Regulatory Planning and Assessment: G.Mansfield
Reference: PB2018/12865

26 November 2018

**MIXED USE DEVELOPMENT (SSD 8440 MOD 1) 42 HONEYSUCKLE DRIVE
NEWCASTLE**

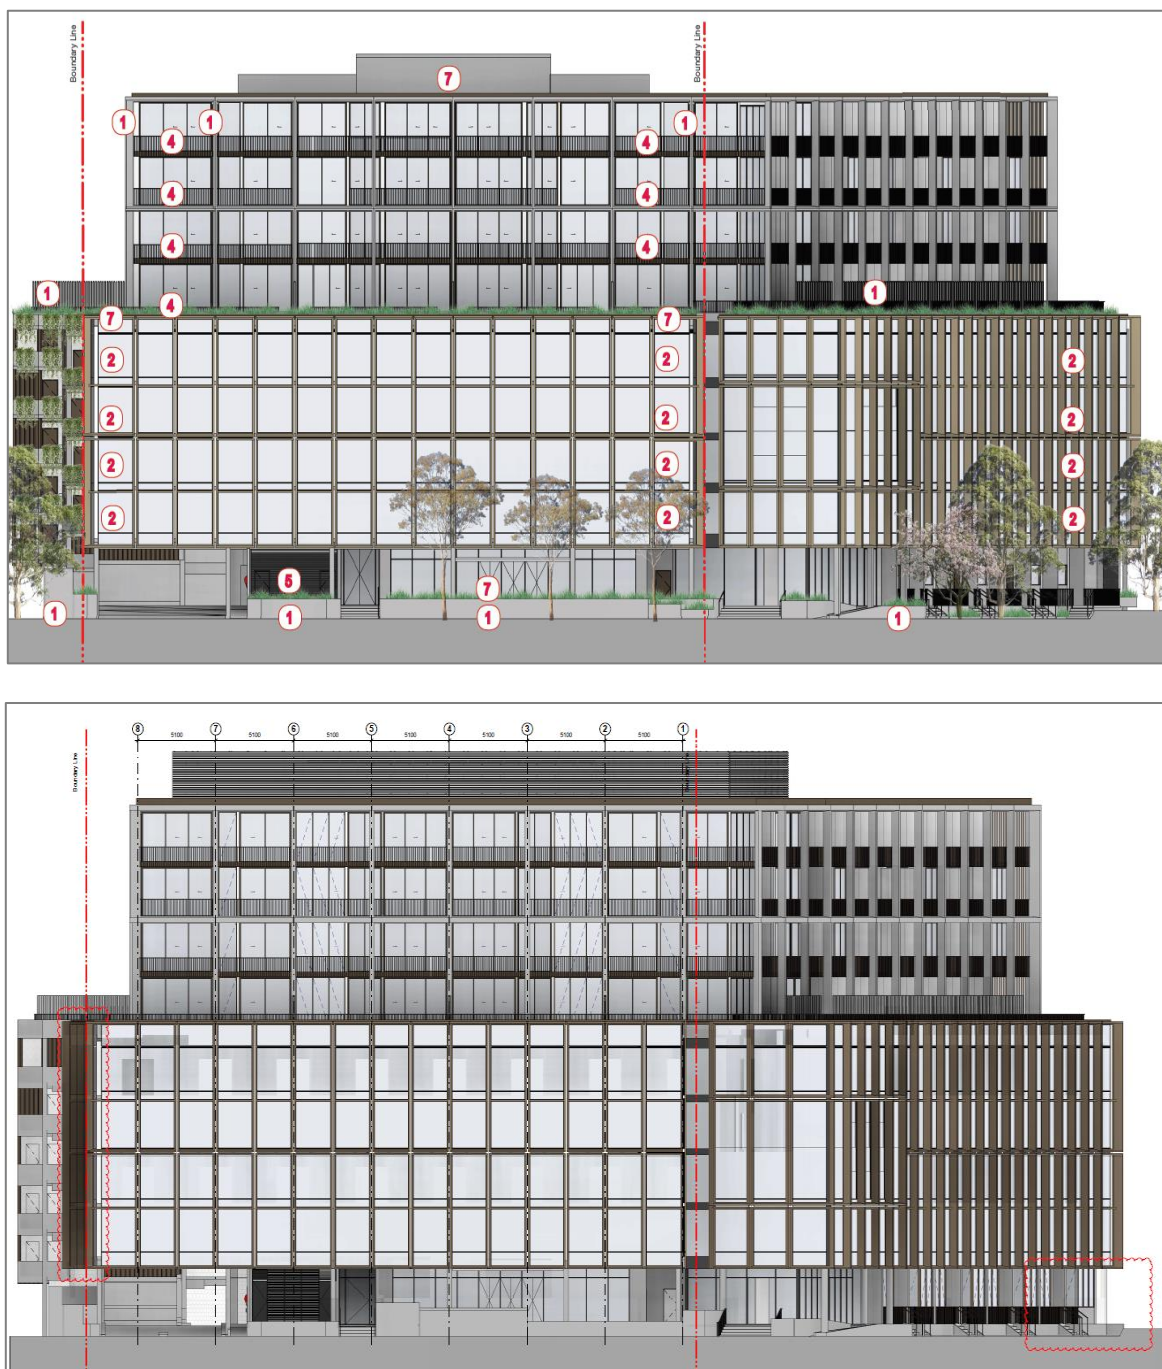
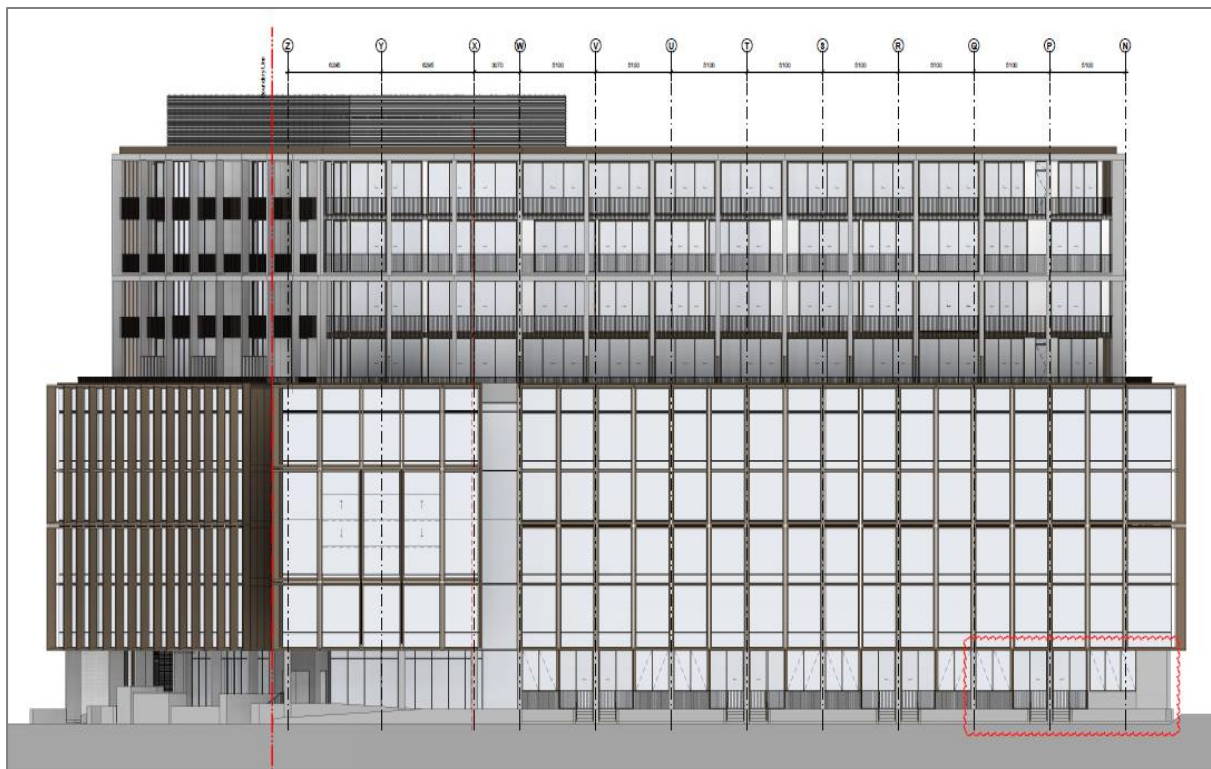
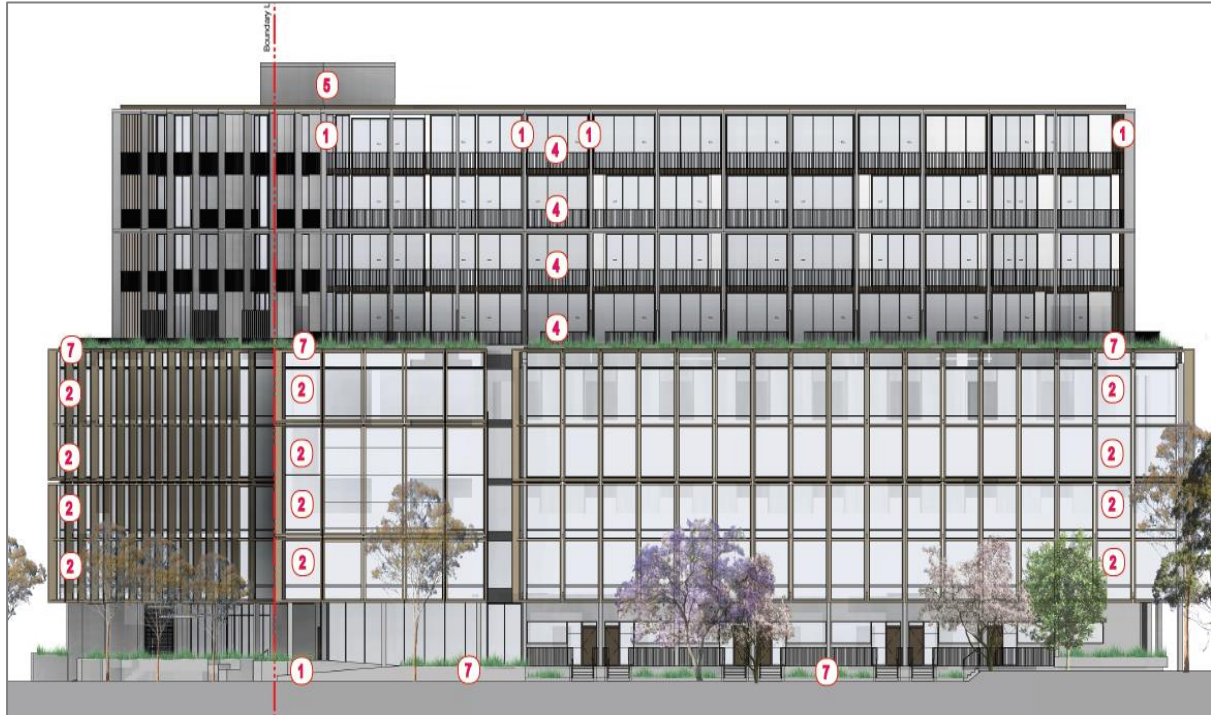
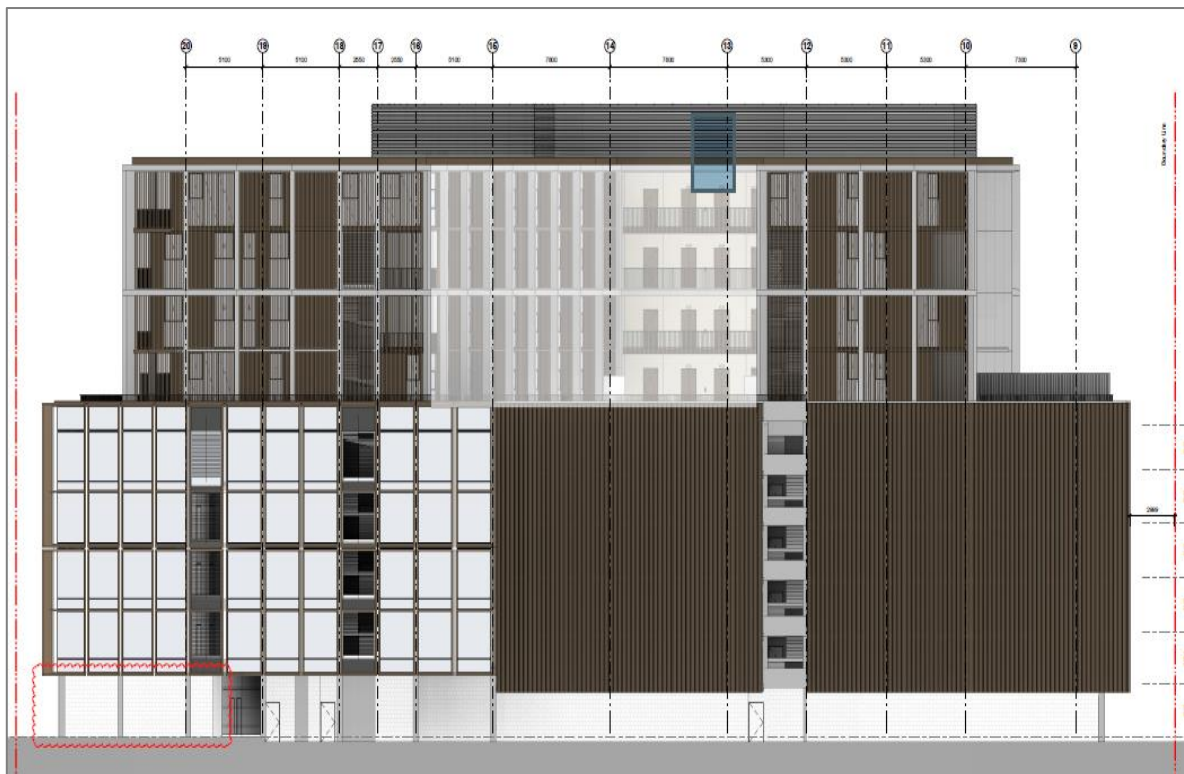
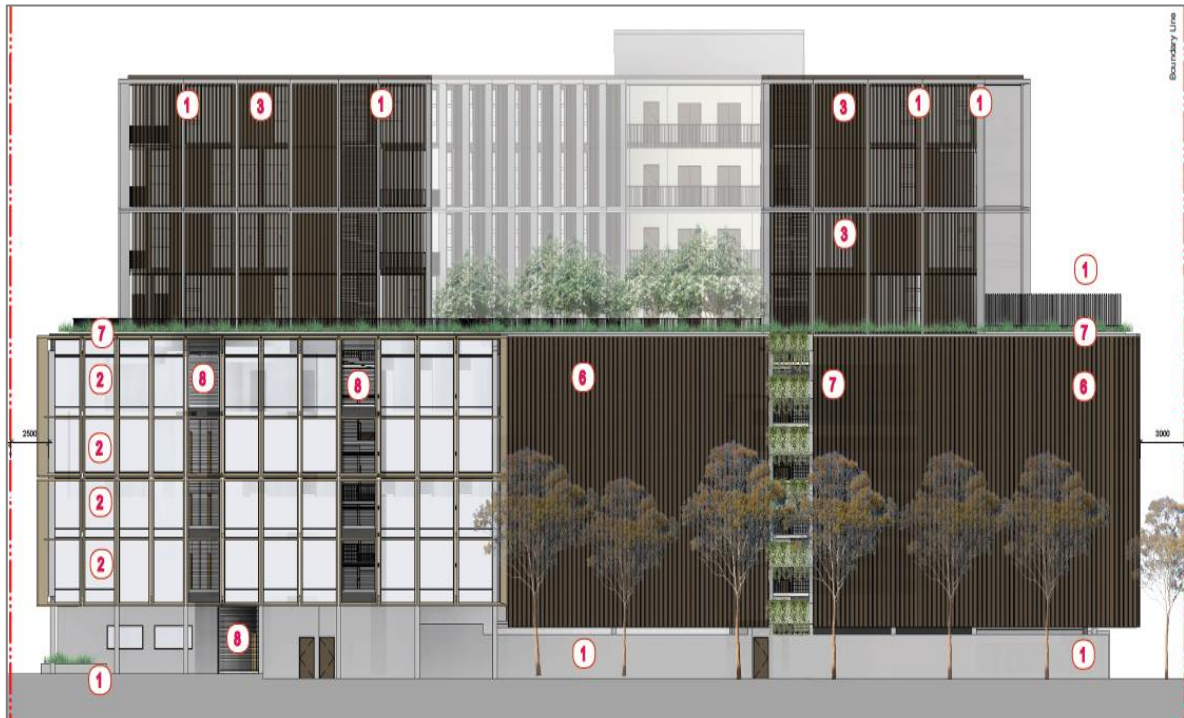
Apart from the alterations to the accessible hotel rooms cited in the report, it is noted a number of other modifications are indicated on the submitted amended plans for which no explanation has been provided. Notably the modifications to the 'plant level' as depicted on the amended elevations.
